M5 Junction 10 Improvements Scheme

Schedule of Change to Volume 2 Plans

TR010063 - APP 9.72

Schedule of Change to Volume 2 Plans at Deadline 4

FOR CONTINUATION REFER TO SHEET 15

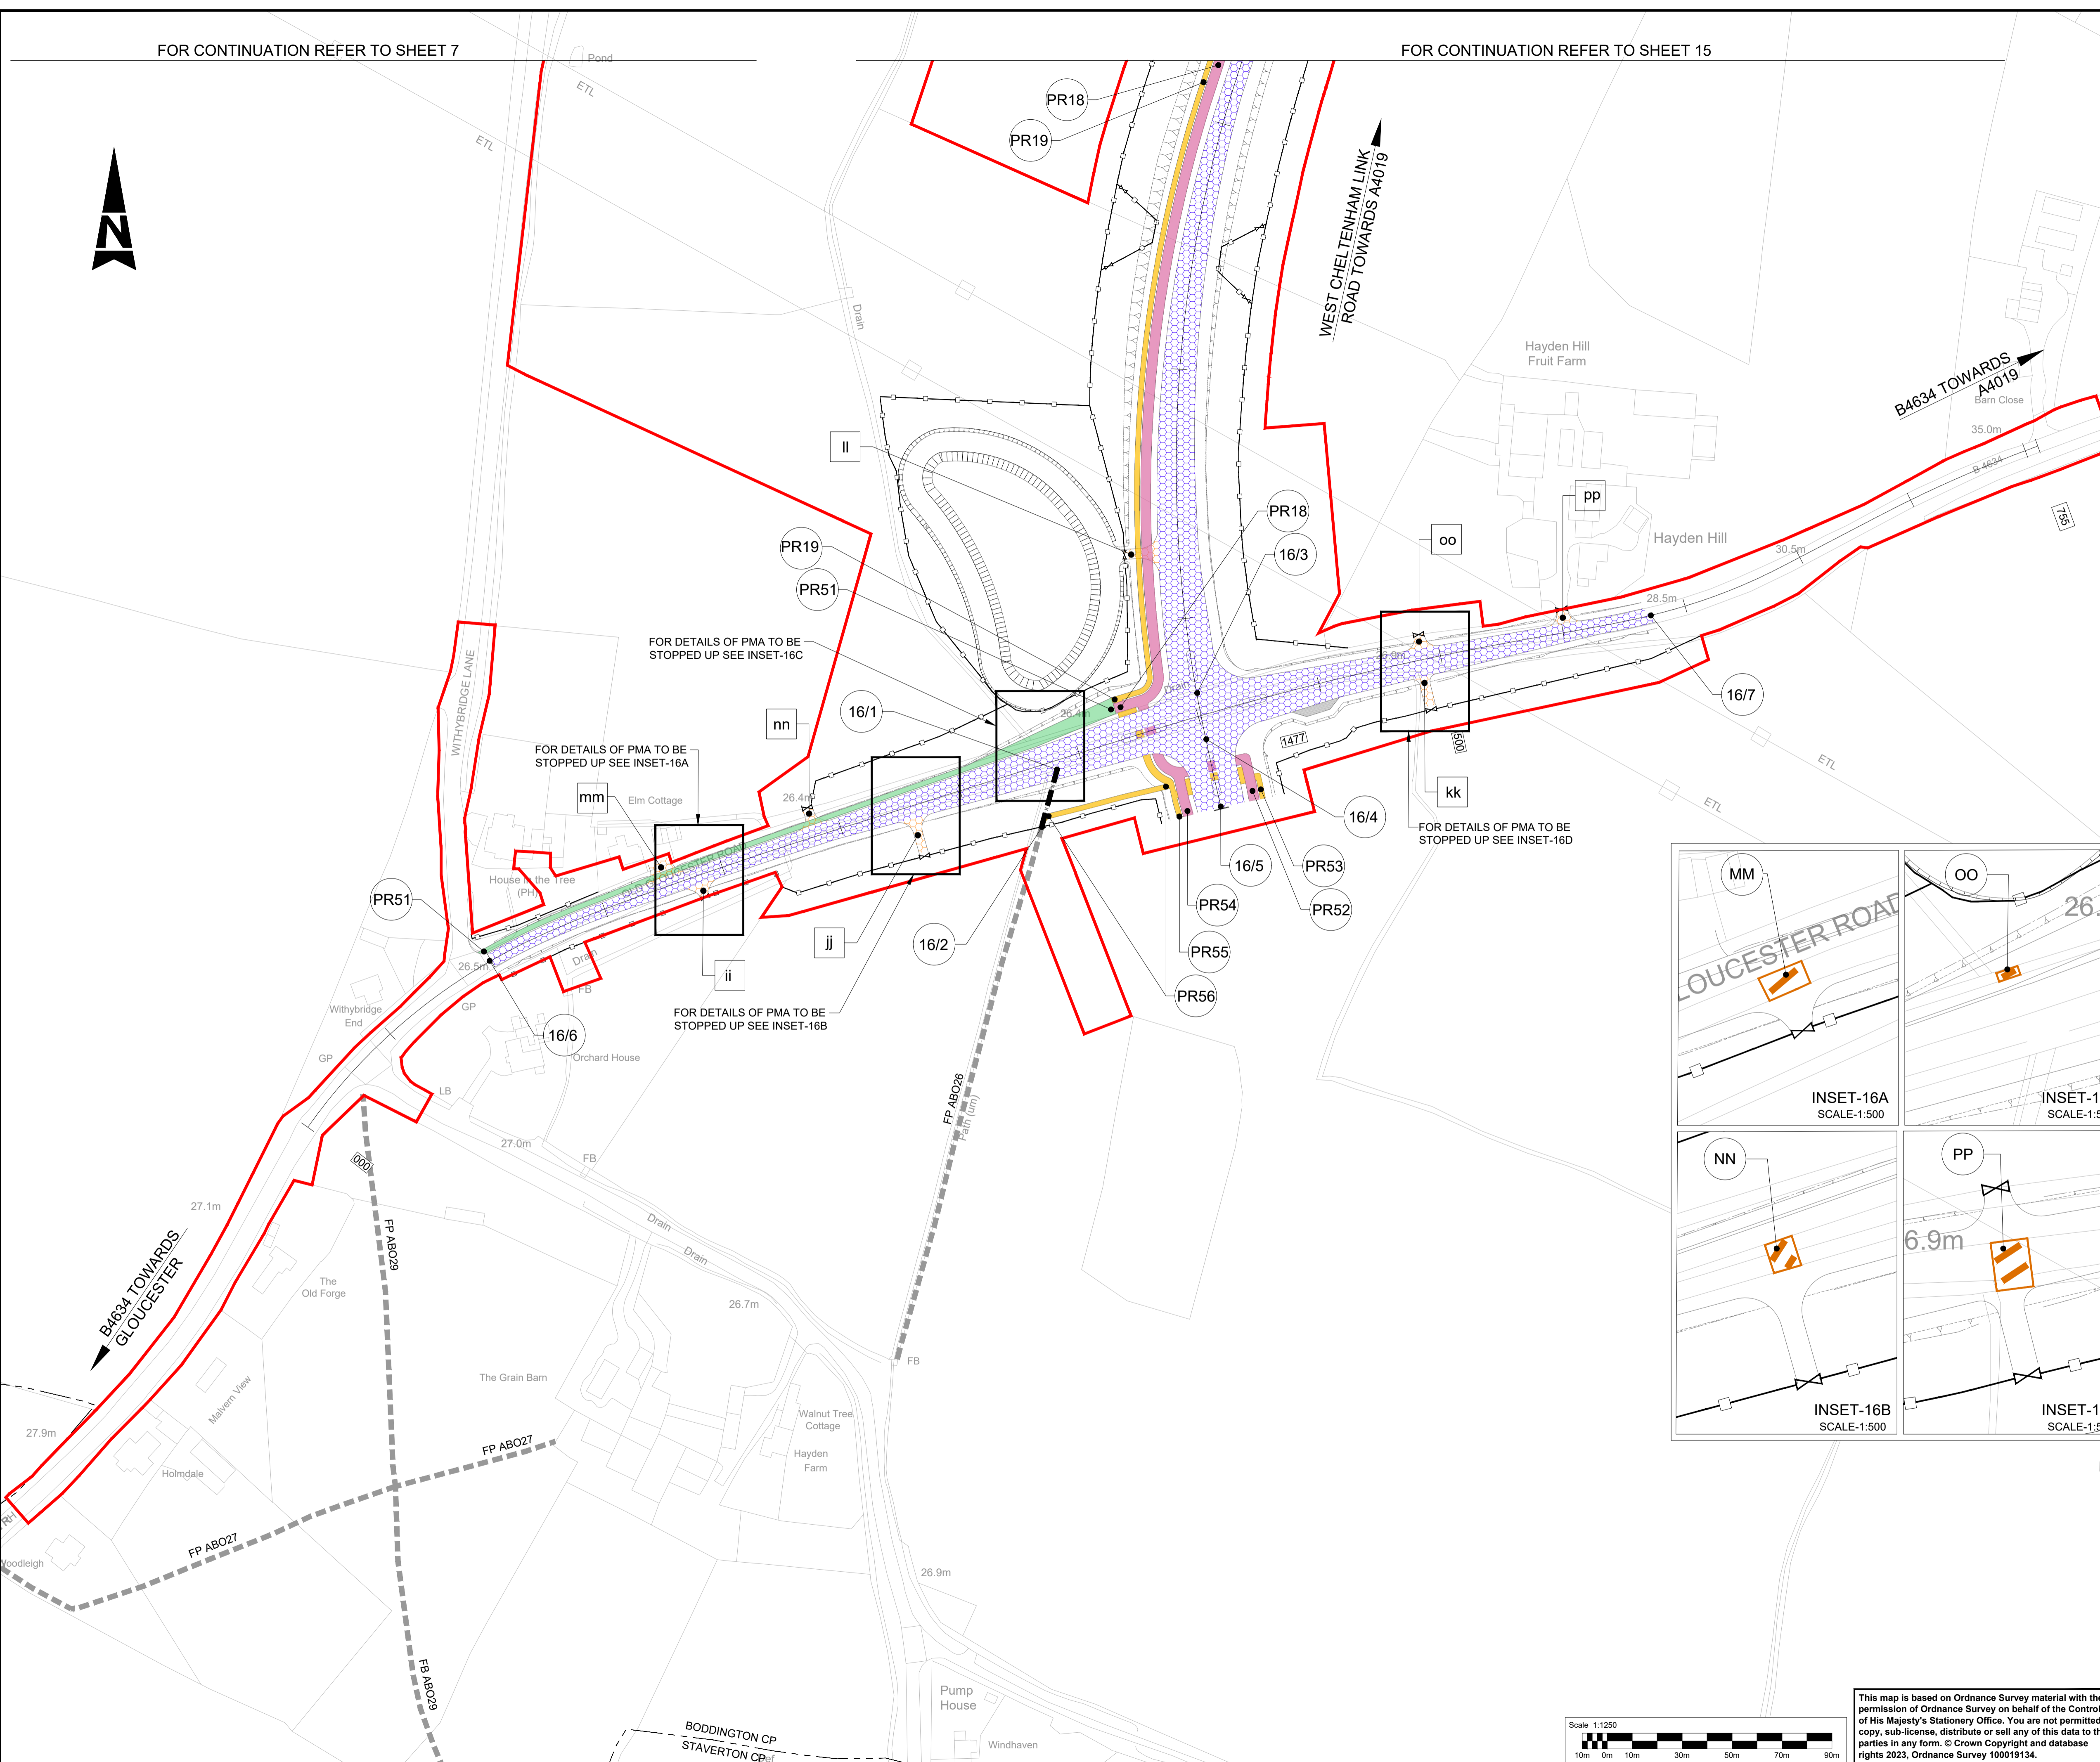
TR010063 – APP 2.5 Part 2	Streets, Rights of Way and Access Plans Sheet 15 of 12	<p>Drawing List Updated – Sheet 15 changed to Rev C02</p> <p>Sheet 15 Amended Amendment in relation to Action Point CAH1.1 – Plot 15/5c</p> <p>PROW is now being diverted to carry up north in a straight line on the east side of the West Cheltenham Link Road, and will re-join the existing FP AUC11 passing through a fence-line to the immediate west of a new gate inserted for an access track. This change has been shown on Sheet 15 of the environmental masterplan, works plan, streets rights of way and access</p>

Document number	Drawing title	Description of change
		plans, and GAs with other plans not requiring to show the updated footpath route. This amendment will remove the proposed PRow diversion from its incursion into Plot 15/5c
TR010063 – APP 2.9 Part 1	General Arrangements	Drawing List Updated – Sheet 15 changed to Rev C02
TR010063 – APP 2.9 Part 2	General Arrangement Sheet 15 of 16	<p>Drawing List Updated – Sheet 15 changed to Rev C02</p> <p>Sheet 15 Amended Amendment in relation to Action Point CAH1.1 – Plot 15/5c</p> <p>PRow is now being diverted to carry up north in a straight line on the east side of the West Cheltenham Link Road, and will re-join the existing FP AUC11 passing through a fence-line to the immediate west of a new gate inserted for an access track. This change has been shown on Sheet 15 of the environmental masterplan, works plan, streets rights of way and access plans, and GAs with other plans not requiring to show the updated footpath route. This amendment will remove the proposed PRow diversion from its incursion into Plot 15/5c</p>
